# Charlotte Department of Transportation

## Memorandum

**Subject:** Rezoning Petition 08-124: Located on the south side of East Boulevard between South Boulevard and Cleveland Avenue (*revised 9/19/08*)

01 SITE PLAN

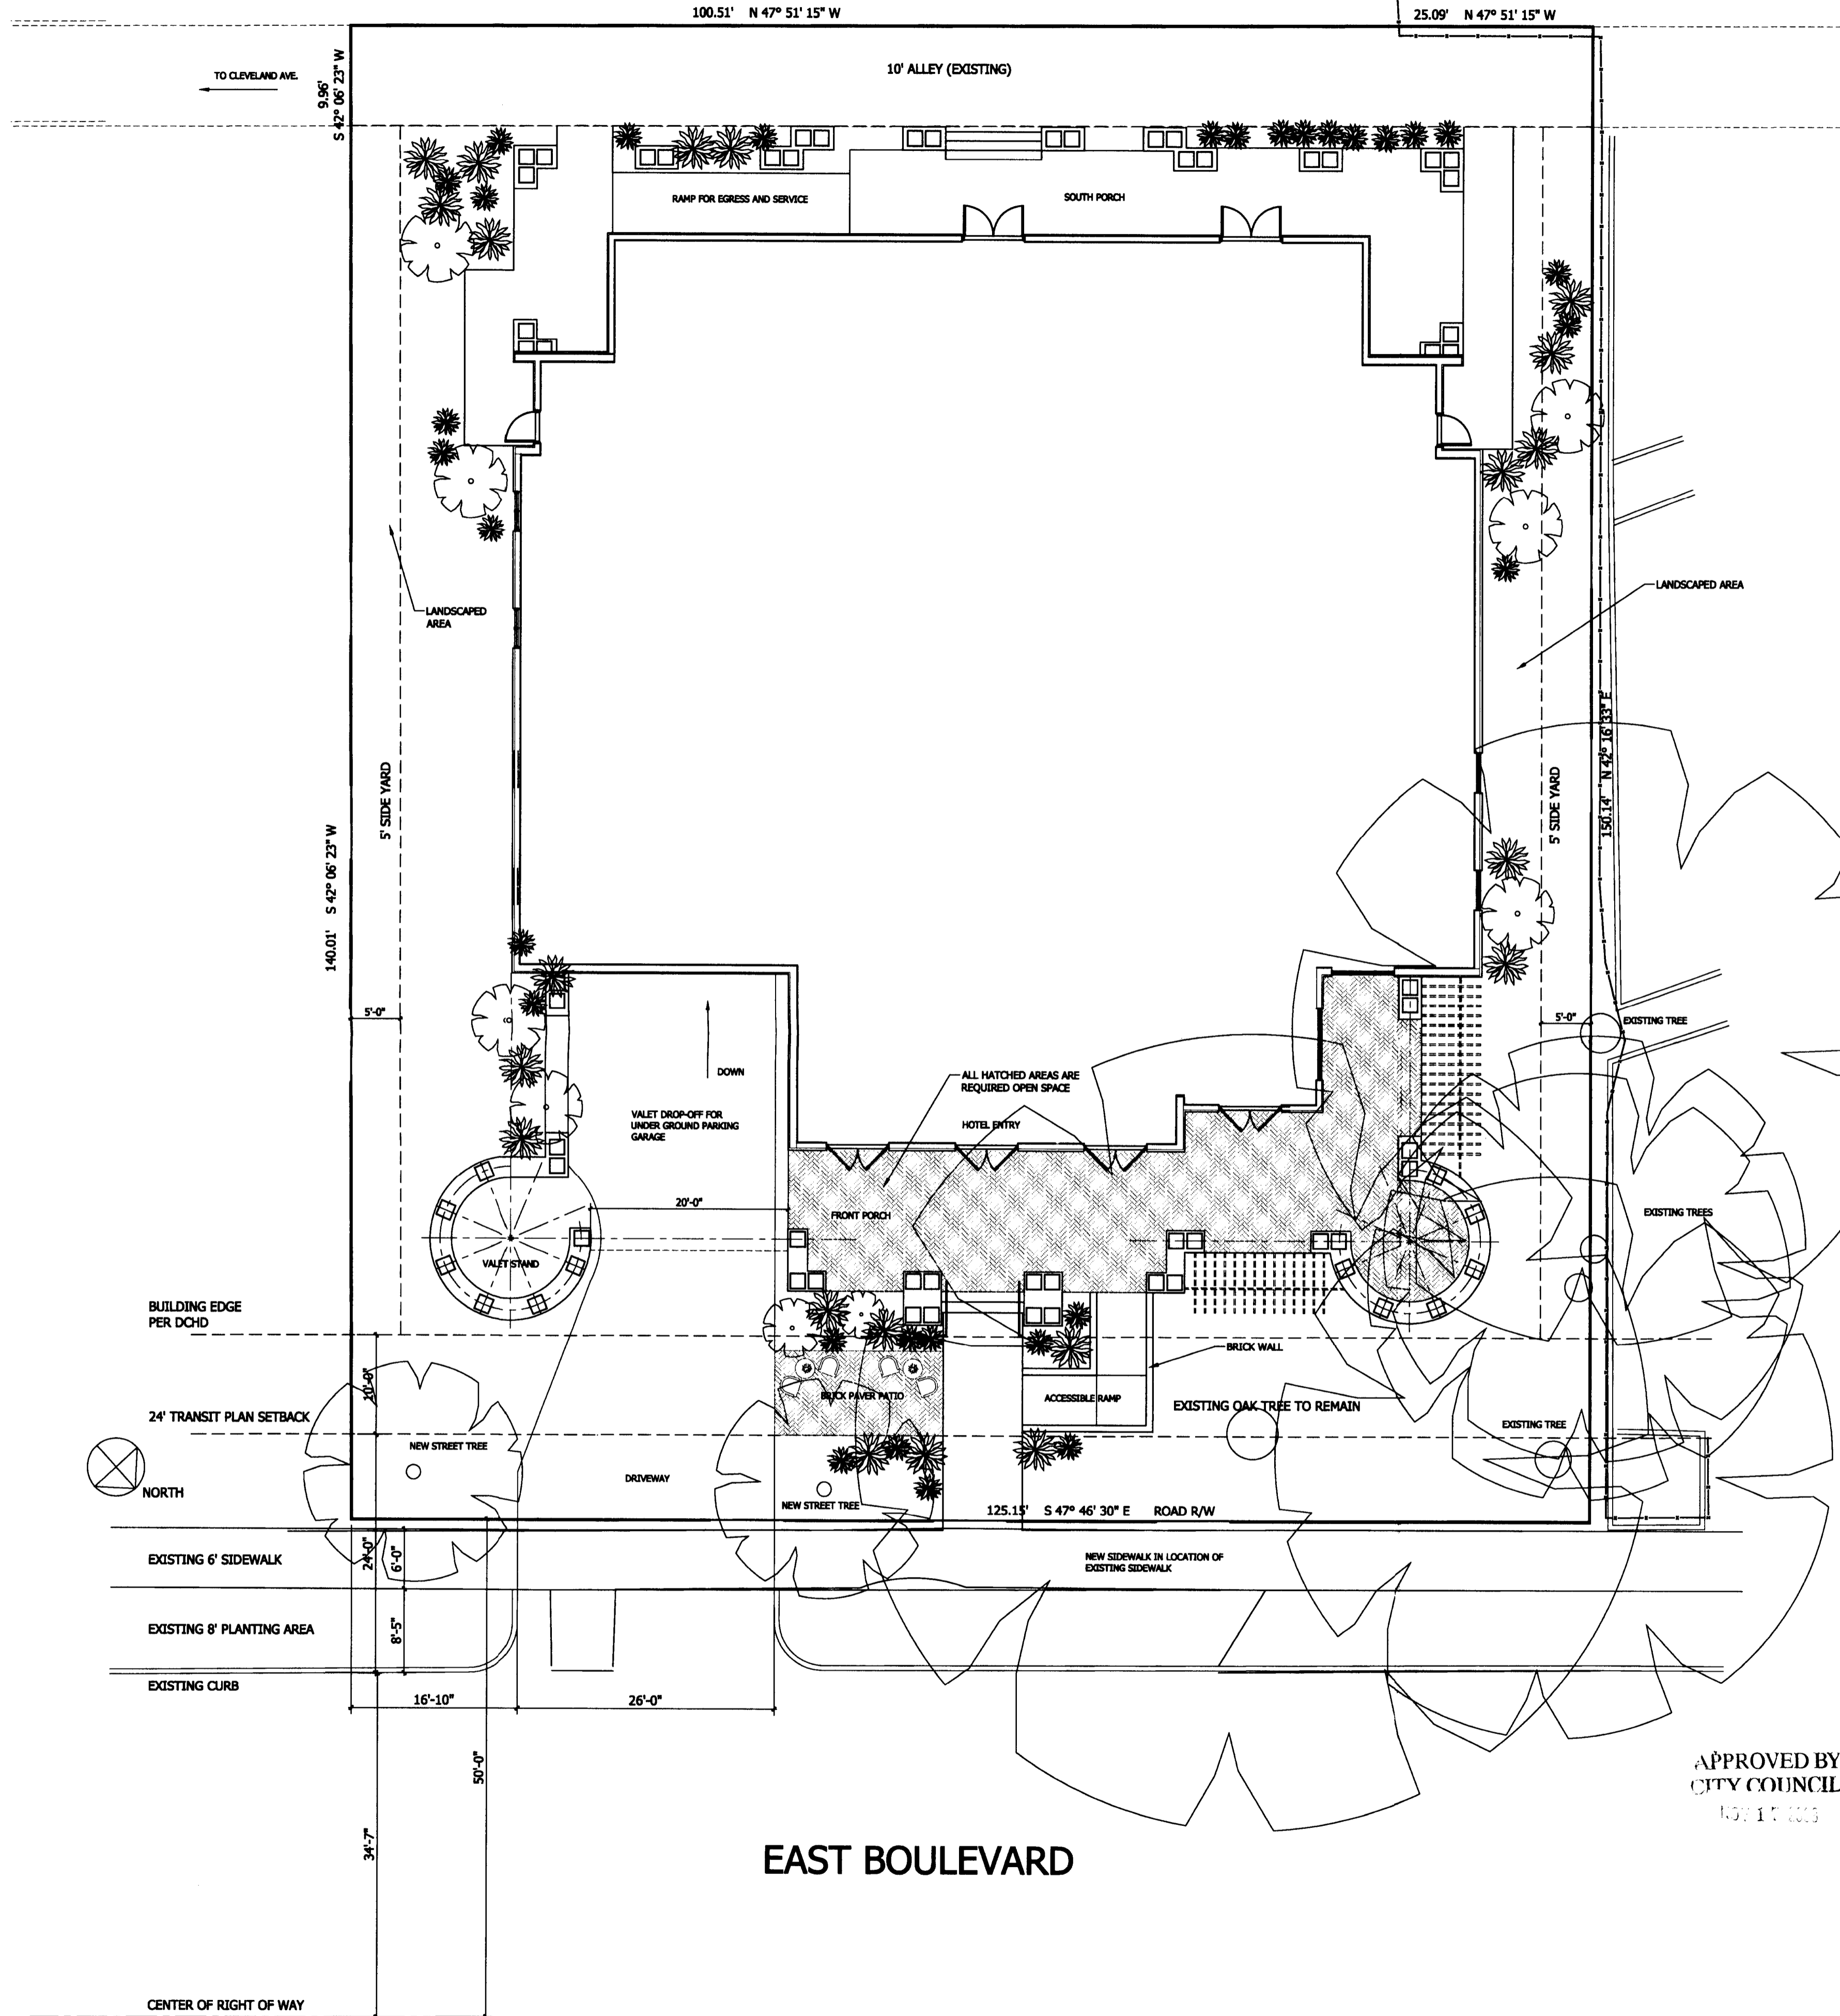
1. The driveway accessing the parking deck will need to maintain a minimum width of 20 feet for two-way operation. As shown on the site plan, the valet stand conflicts with this requirement. (*Previous review comment*)
2. We are not in support of the request to eliminate the required on-site delivery/loading space. If this function is not provided on-site, then service vehicles will need to be stopped/parked

in the alleyway in order to make deliveries and block access to other parcels accessed via the alleyway. (*Previous review comment*)
